**RE: Triview Metropolitan District
Northern Delivery System – Booster Pump Station
Site Development Plan – Comment Response Letter
PPR-2262**

Below are responses to comments provided 05/16/23 – 05/22/23 for agency review of the above-referenced project. We have inserted our responses and actions taken in **blue** below each comment.

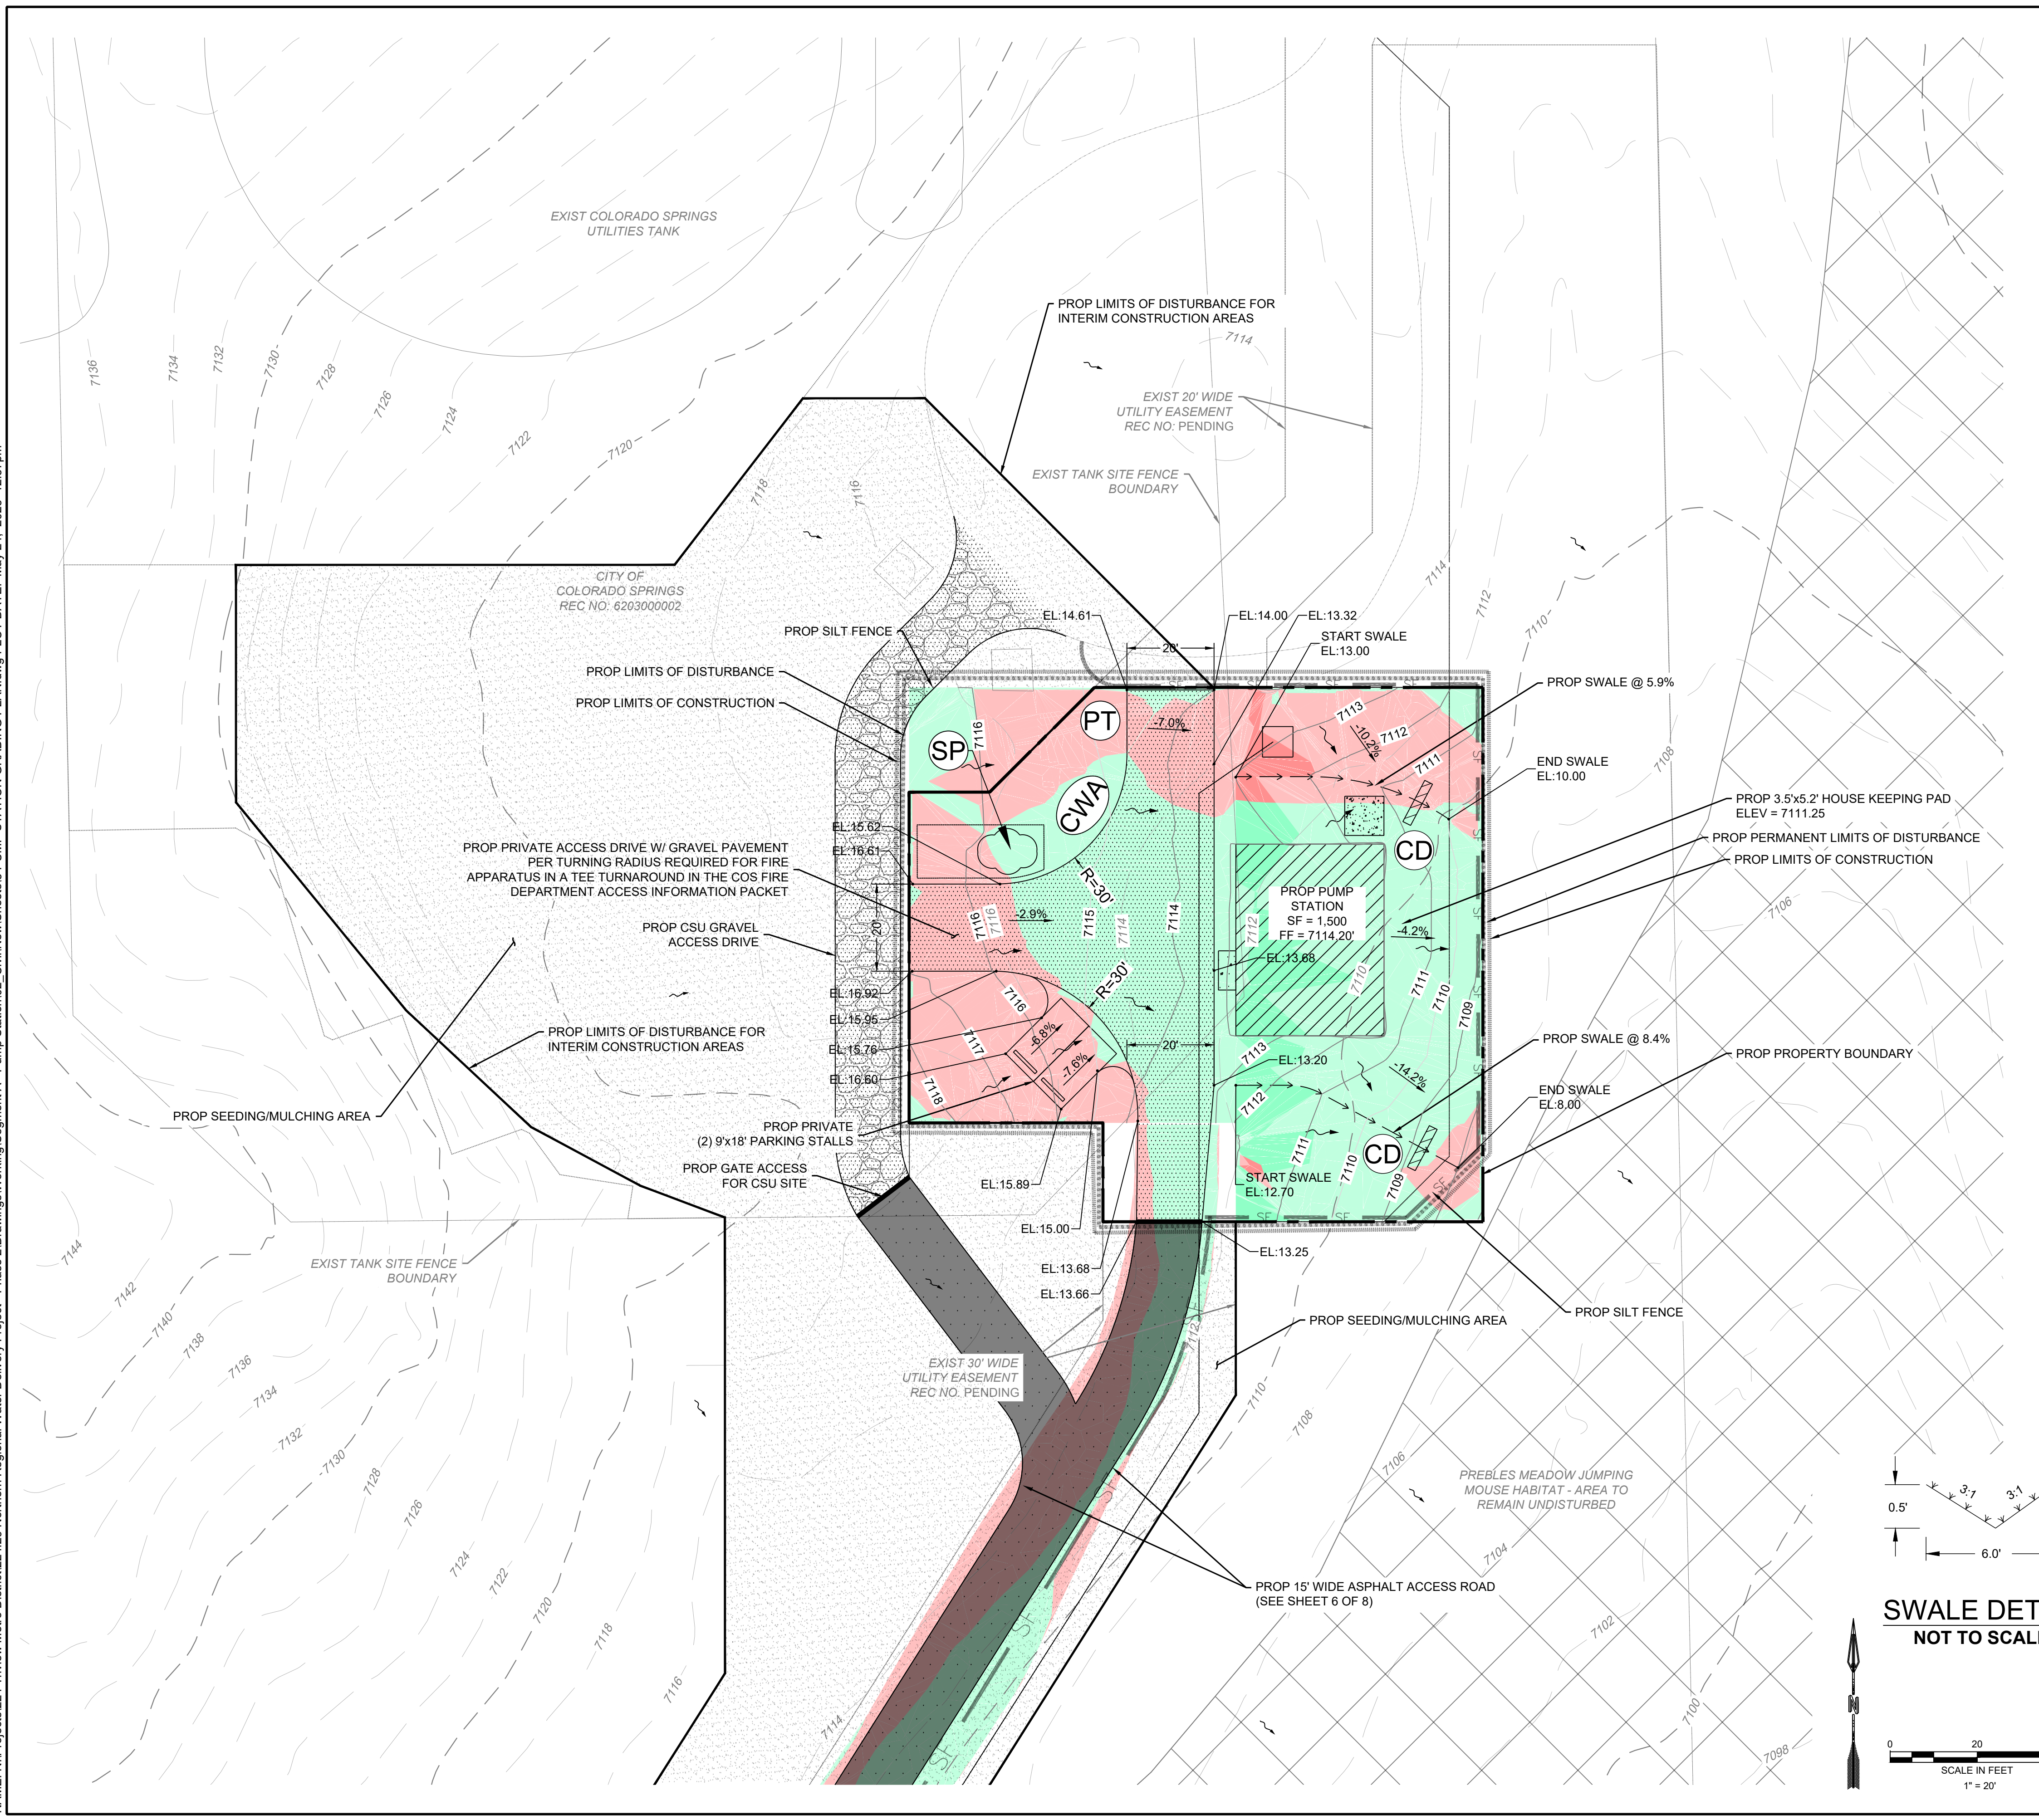
4. Show location of silt fence (page 6).

Complete. Silt fence has been added to each plan sheet, as needed.

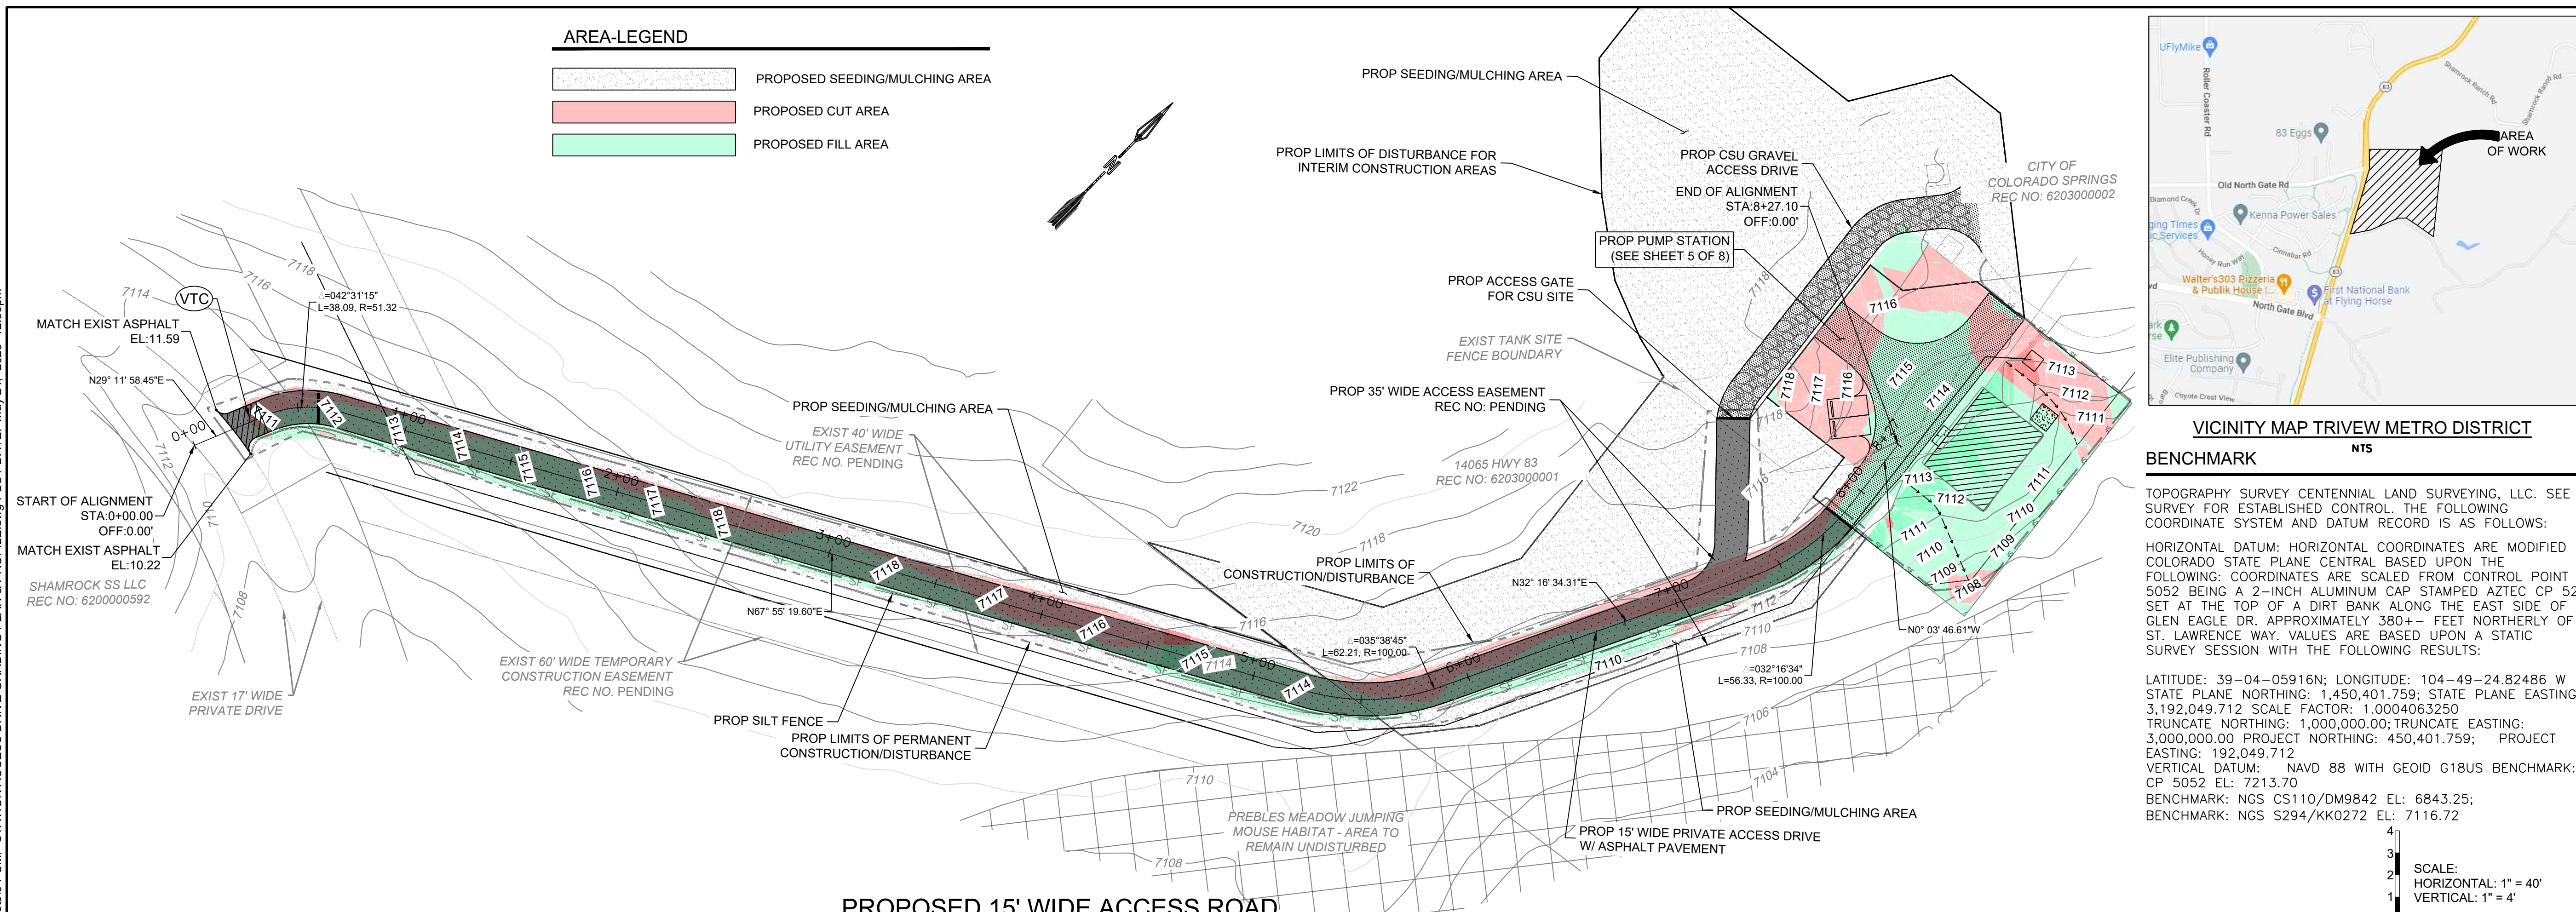
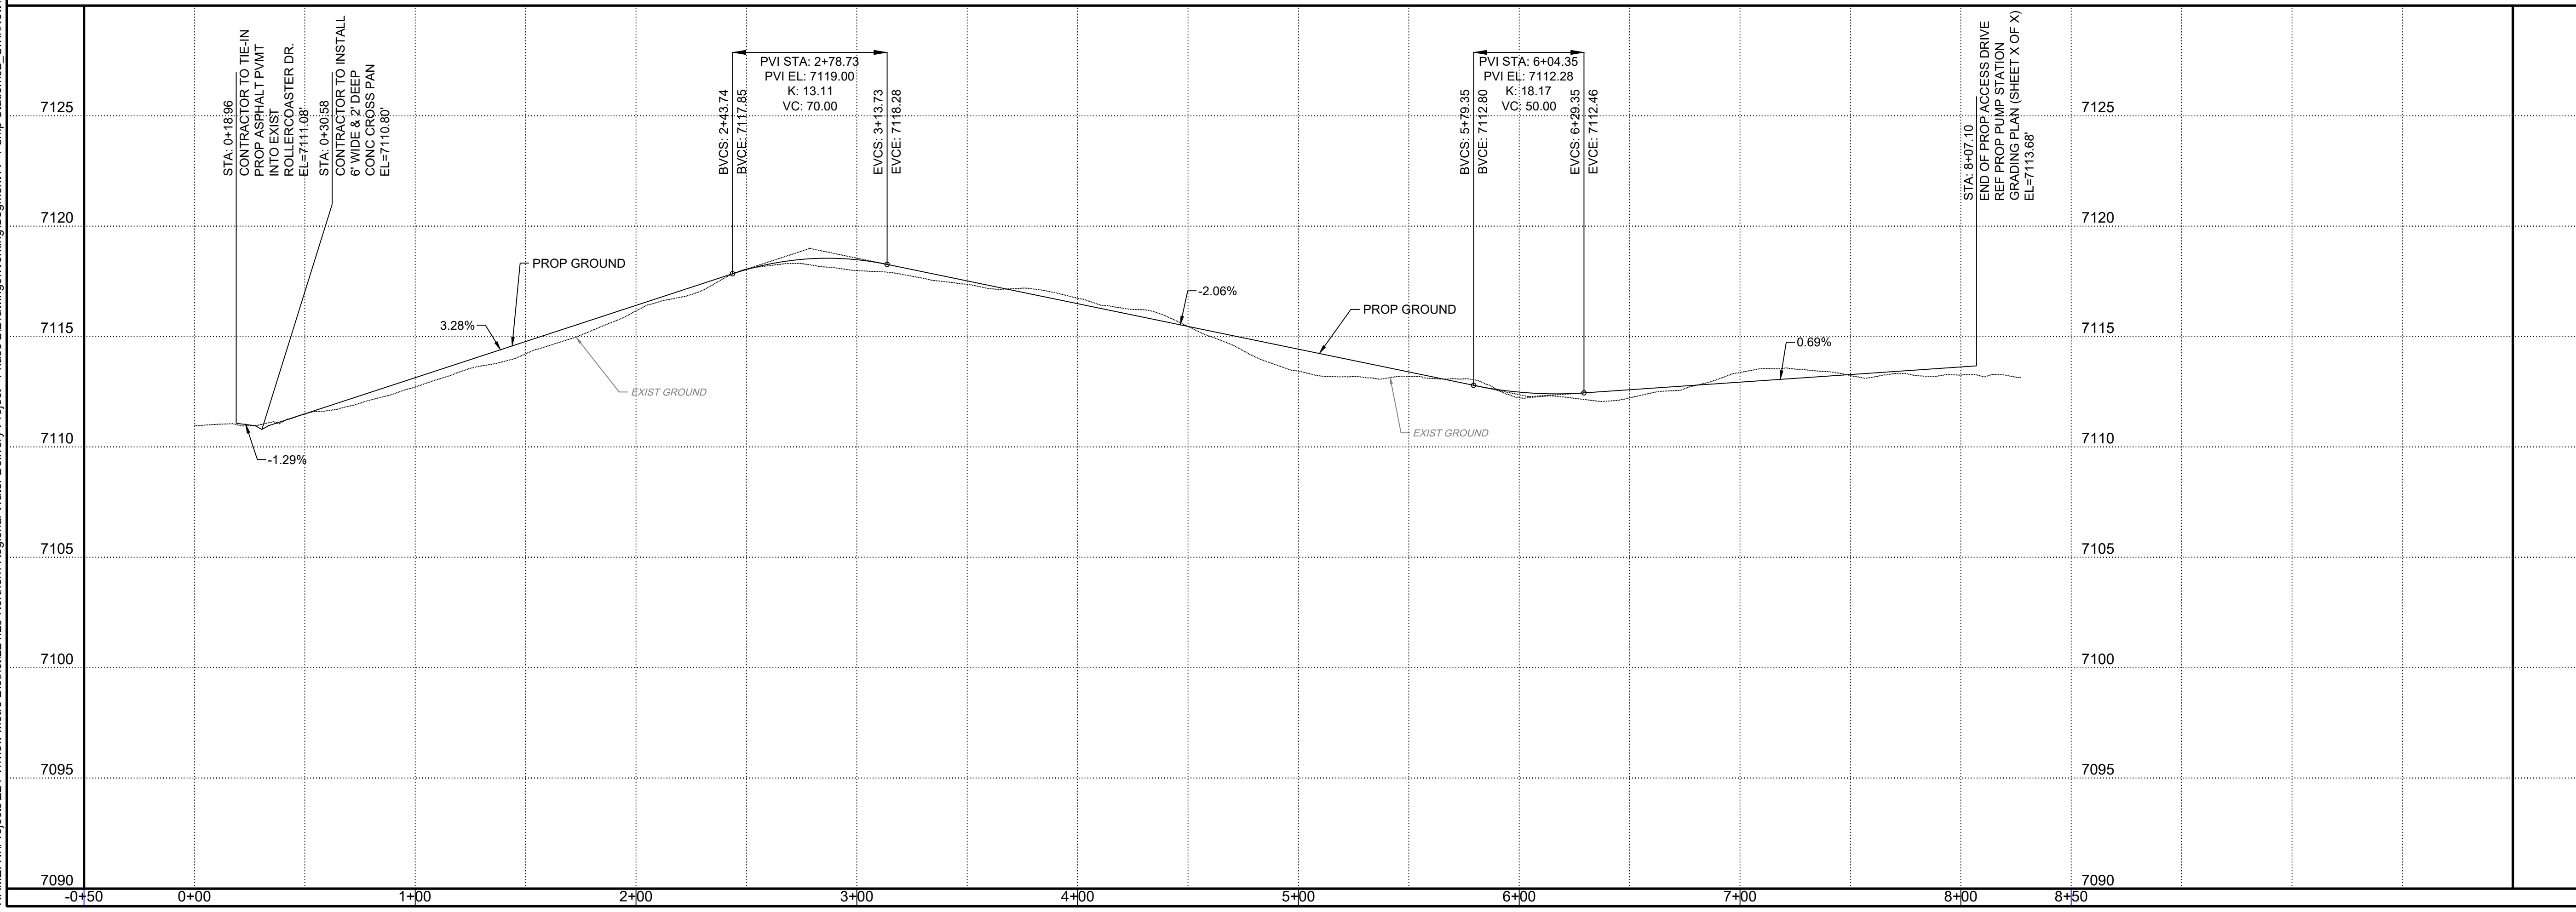
1. Show silt fence on figure (page 5).

2. Show areas of cut/fill. Show all areas of seeding/mulching (page 5).

3. Differentiate between the two flow arrows (page 5).

Complete. Silt fence has been added to each plan sheet, as needed.

Complete. Cut and fill areas are color coded to more easily see where each occurs. Hatching was added to the plans to indicate areas of seeding and mulching occur.

Complete. The flow arrow designations were modified to better illustrate existing versus proposed.
